Demolition of existing dwelling & erection of a 71 bedroom care home (C2 Residential Institution) with car park, landscaped gardens & access from Roundstone Lane. This application is a Departure from the Development Plan.

Pound Place Roundstone Lane Angmering

Thank you for your internet representation made on 11th May 2018 which has been recorded as '**an objection**' with the comments as follows:

**TREE PROTECTION PLAN**

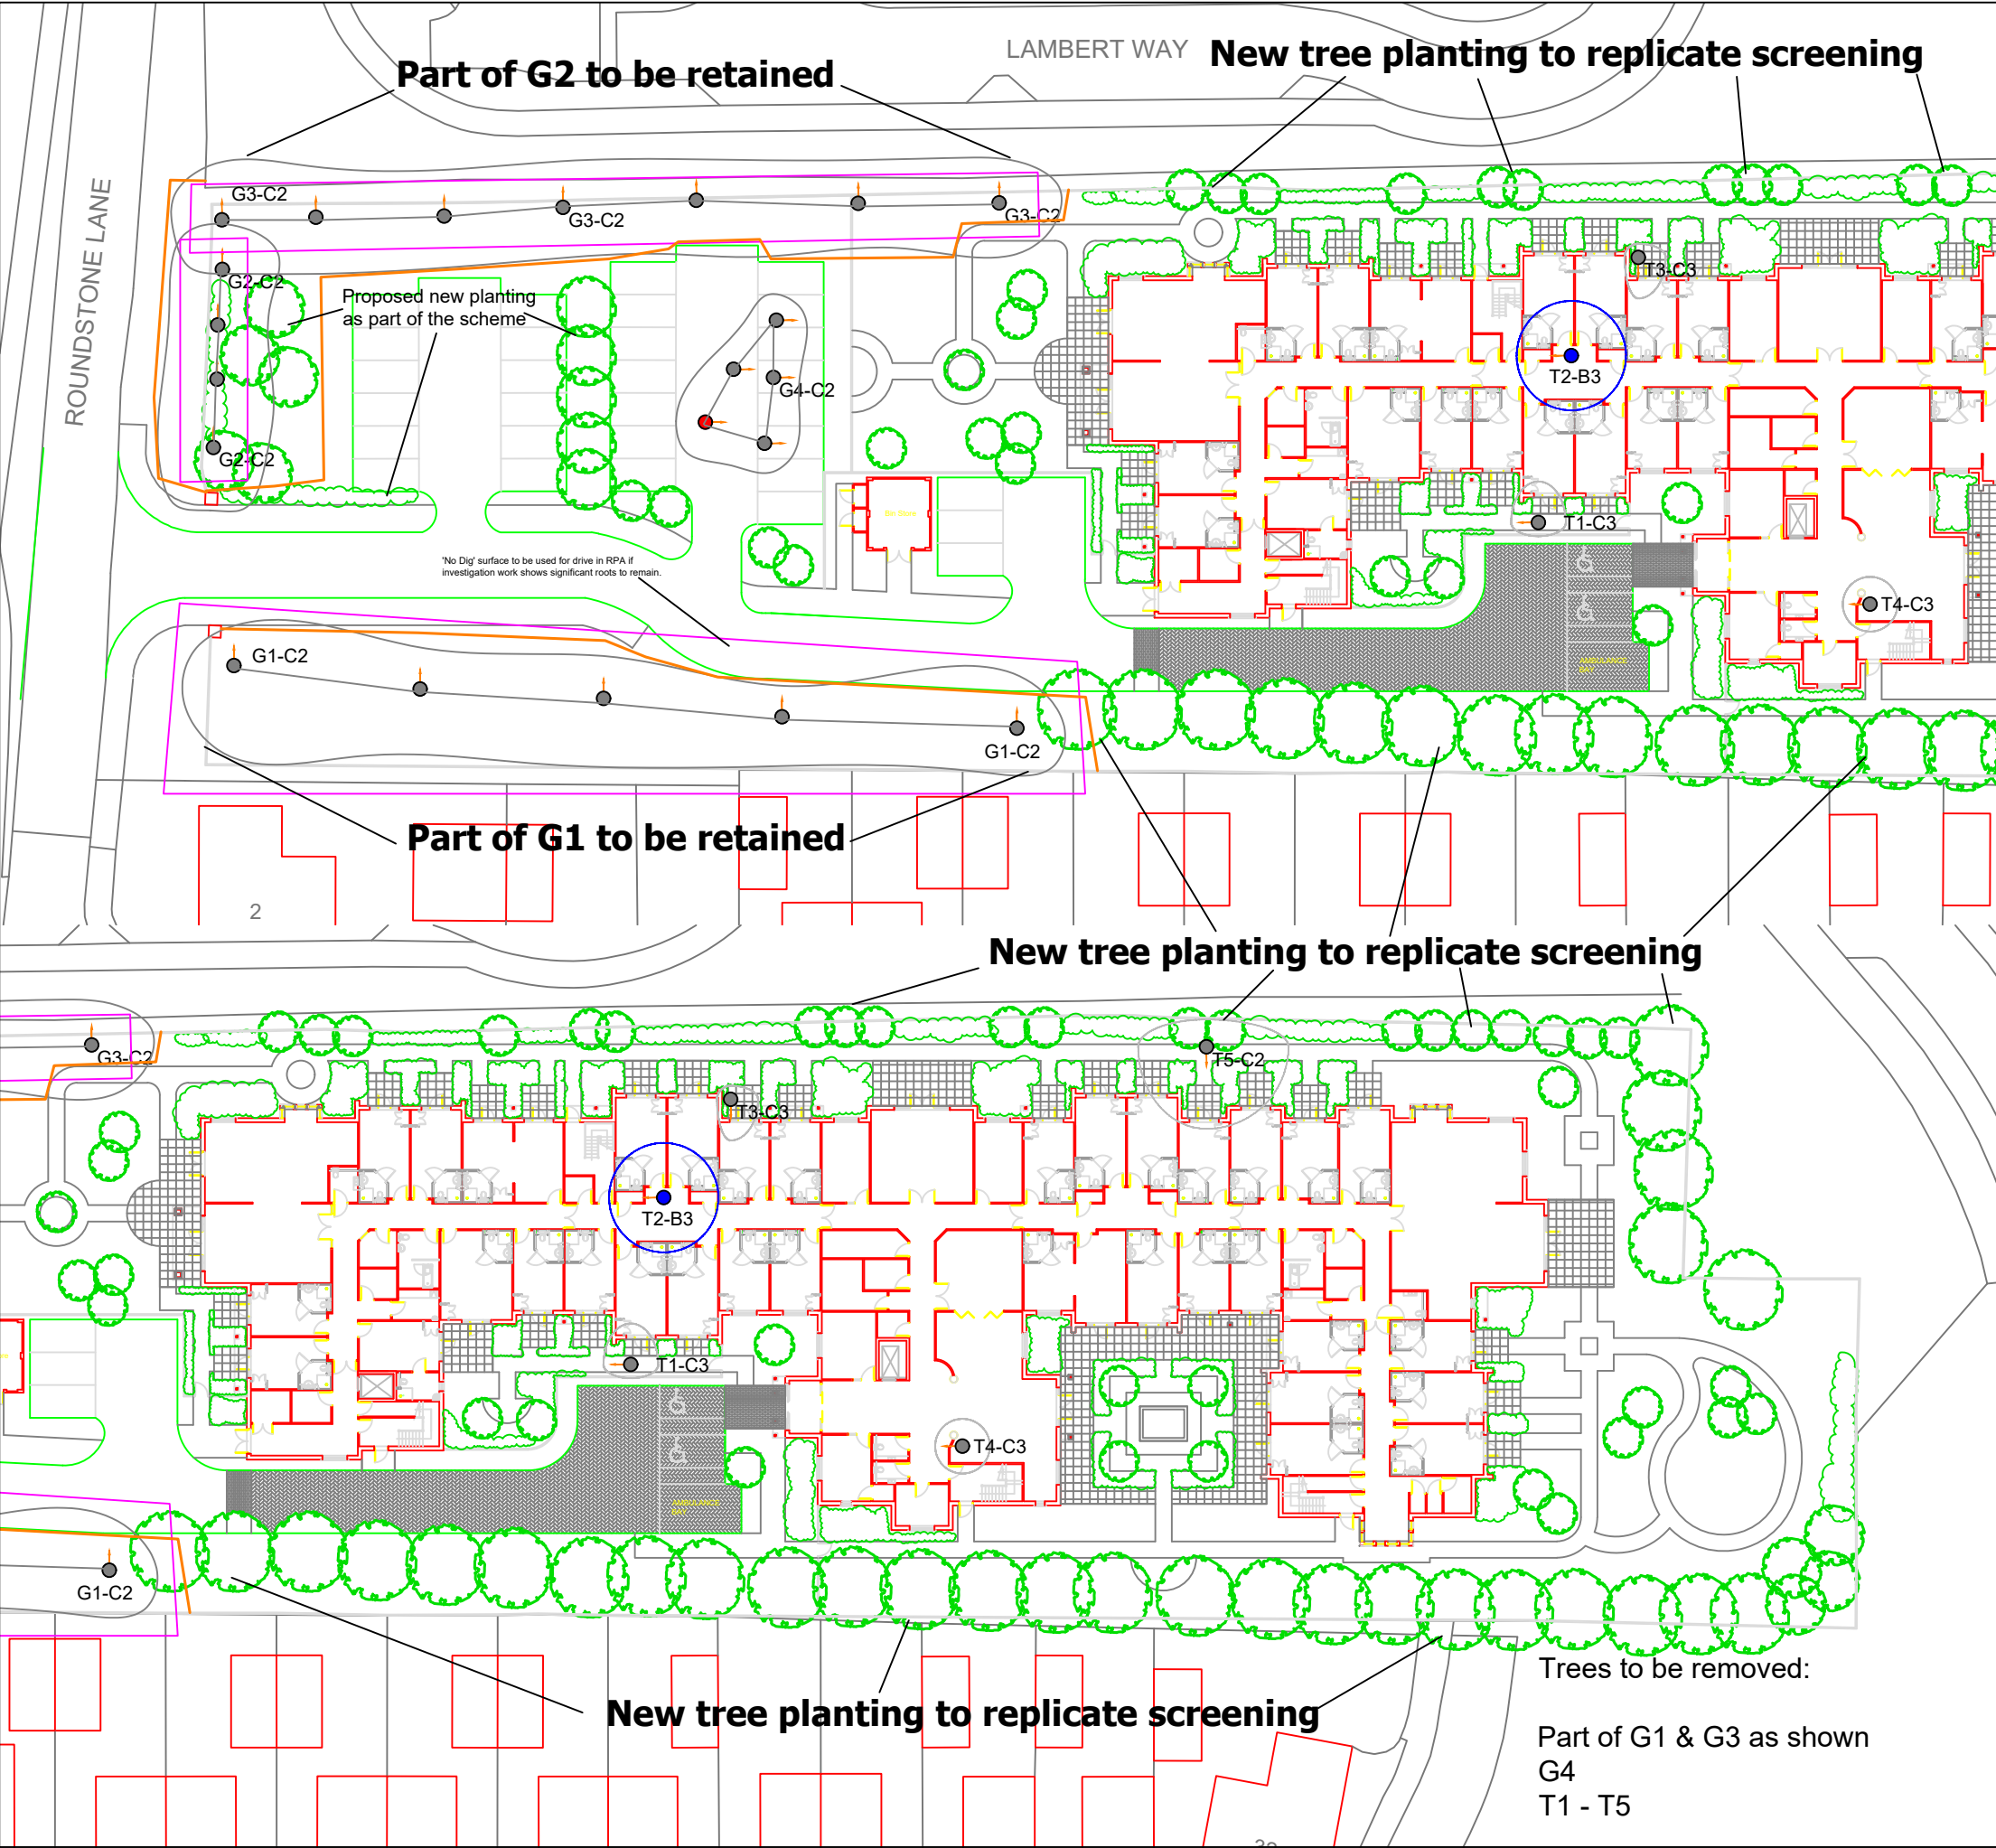
Whilst I am not against the principle of the development, I feel greater protection should be given to the Trees that are currently subject to a TPO and also the need for more parking spaces.

1. Trees - those that surround Pound Place are of a substantial height and provide a beneficial effect in separating housing developments, thereby enhancing people's appreciation of the area whilst contributing to the 'green' character of the area more generally. They also provide an arboreal buffer that helps protect the setting of the South Downs National Park, a duty that ADC is obliged to consider.

Whilst the individual variety of the majority of trees may not be of special note (X Cupressocyparis Leylandii) they are, because of their size and prominence, highly visible from Roundstone Lane, particularly the Western Boundary as well as their Northern and Southern boundaries which help to separate the new developments and contribute to the overall public amenity.

These trees also provide shielding to the urban development of Bramley Green and the newer development on Brougham Grove (Former Pound Nursery) from the South Downs National Park. The loss of these trees will compromise the views from the SDNP.

The trees on the Western Boundary help shield any future development as seen from Roundstone Lane, again contributing to the rural character of the area.

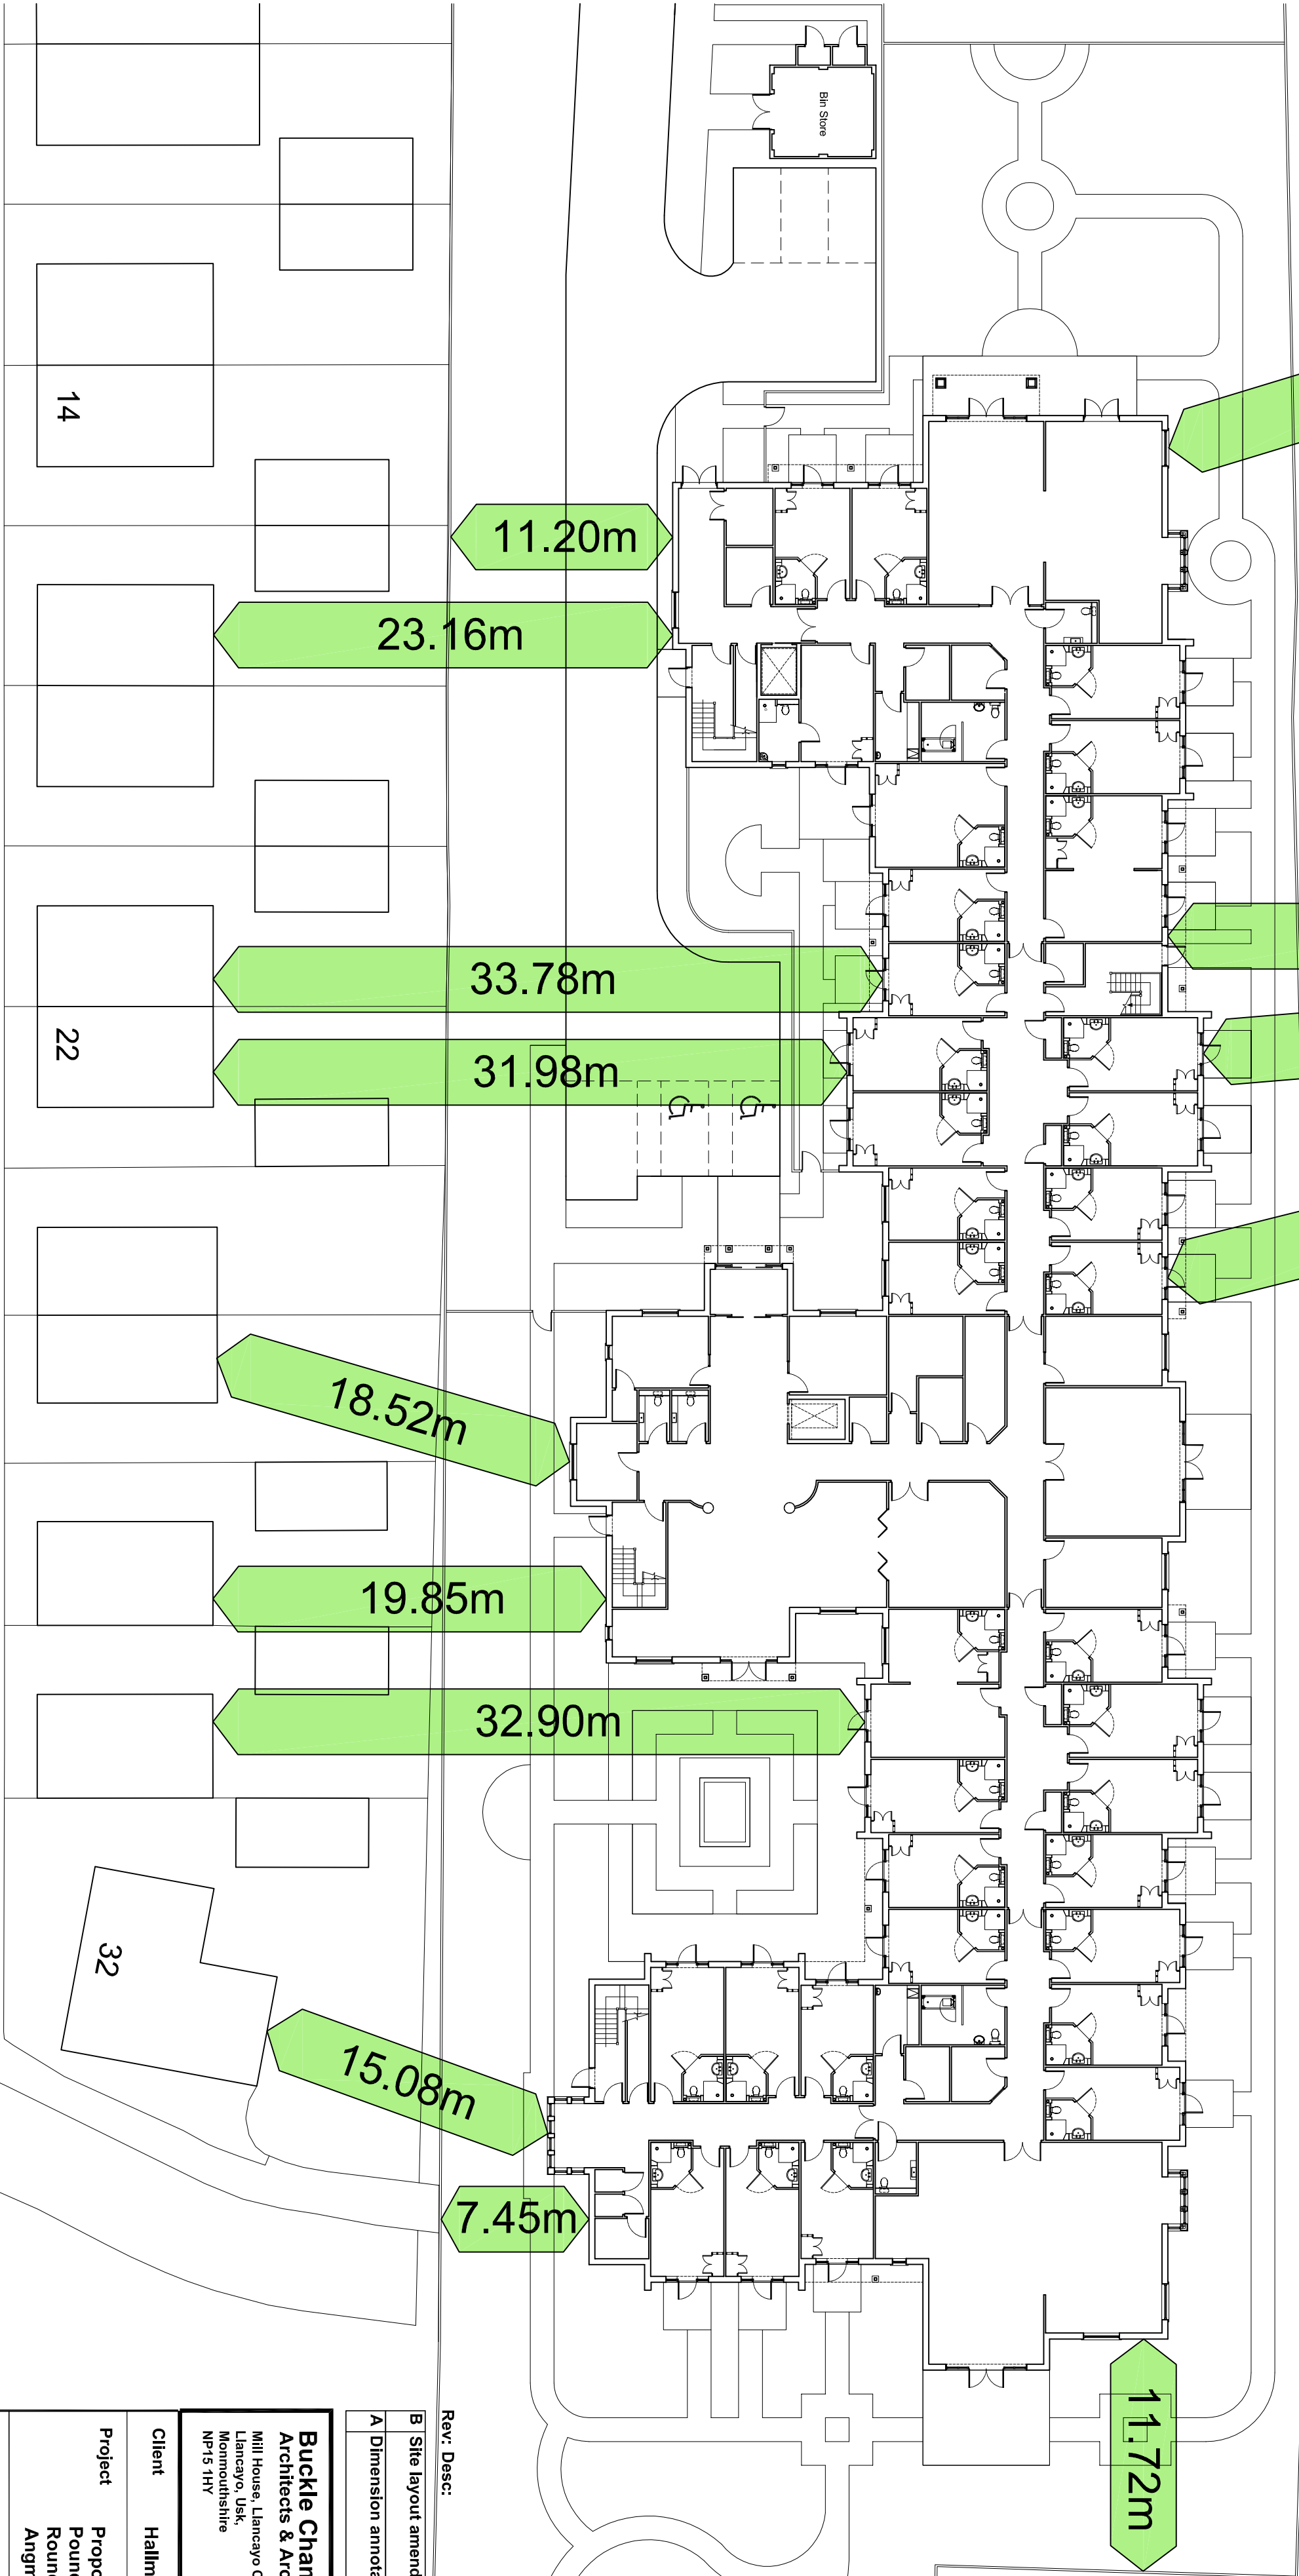
2. Parking Spaces - given the amount of staff required for the Care Home, there seems to be an expectation that staff will not be using cars to commute but cycles or public transport. Given the skills required, I think it is unrealistic to expect to recruit staff in numbers that all live in such proximity to the home. I would suggest the amount of car parking spaces should be increased.
